CITY OF ALBUQUERQUE

June 19, 2018

RE: 1422 Van Cleave Road NW
Grading and Drainage Plan
Stamp Date: 5/23/18
Hydrology File: G13D034

DRAINAGE AND GRADING PLAN

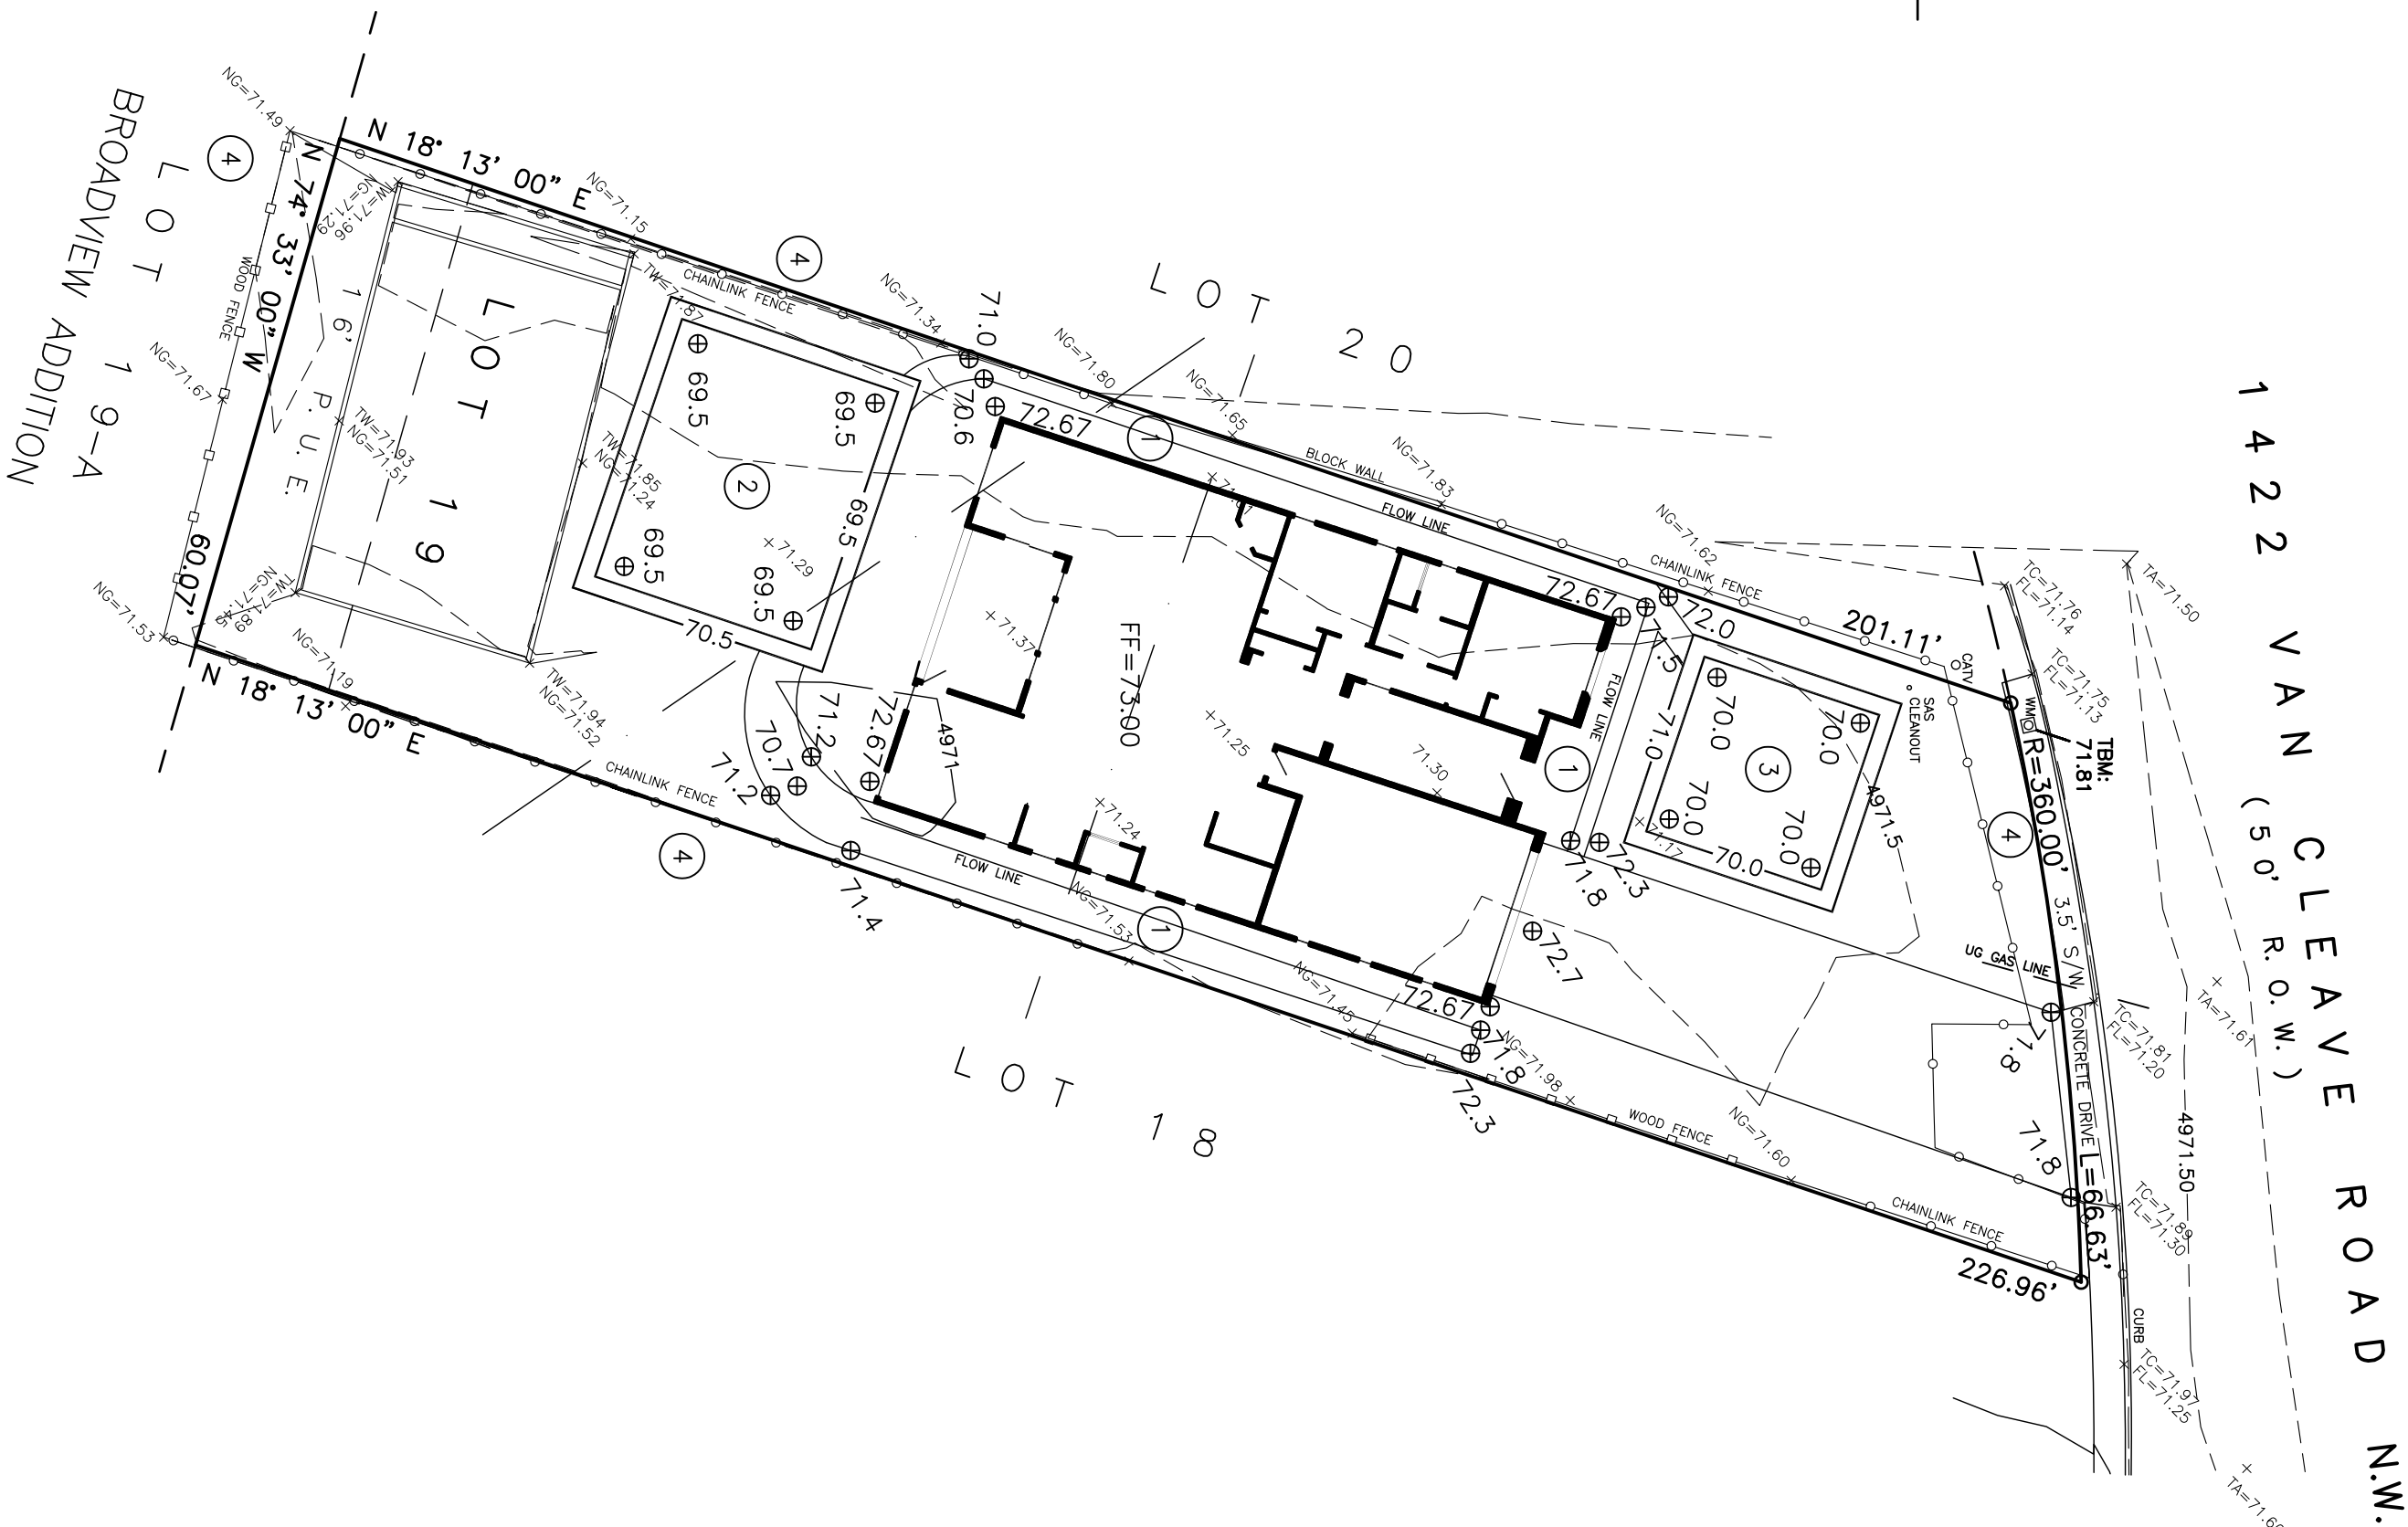
1. Please provide the FIRM Map and flood plain note with effective date. This site is in Zone "X" (Area with reduced flood risk due to levee) per FEMA FIRM Map 35043C2125D dated March 18, 2008. Please do not reference any other flood hazard maps since these are not accurate for flood insurance.

2. Since this site is in the Valley region and in Zone "X" (Area with reduced flood risk due to levee), please follow Chapter 22 Section 5.G (Flat Grading Scheme). The following conditions must be applied to the site:

- a. The maximum percent impervious of the lot and the contributing area may not be greater than 45%.
 - b. Pad elevation shall be a minimum of one (1) foot above the 100 year 10-day storm water surface elevation.

- c. The flow between the front yard and back yard cannot be obstructed. The storm water must be allowed to equalize to the same level between the front yard and back yard.

- d. A permanent perimeter wall or barrier around the development is required to contain the 100 year 24 hour storm developed runoff.
 - e. The high point of the street should be four inches above the 100 year 10-day storm water surface elevation.

Also a retention pond is required. The required volume = (3.67 in. X impervious area / (12in/ft)). The location with elevation of pond and the calculation of both the required and actual volume needs to be shown on the Grading Plan.
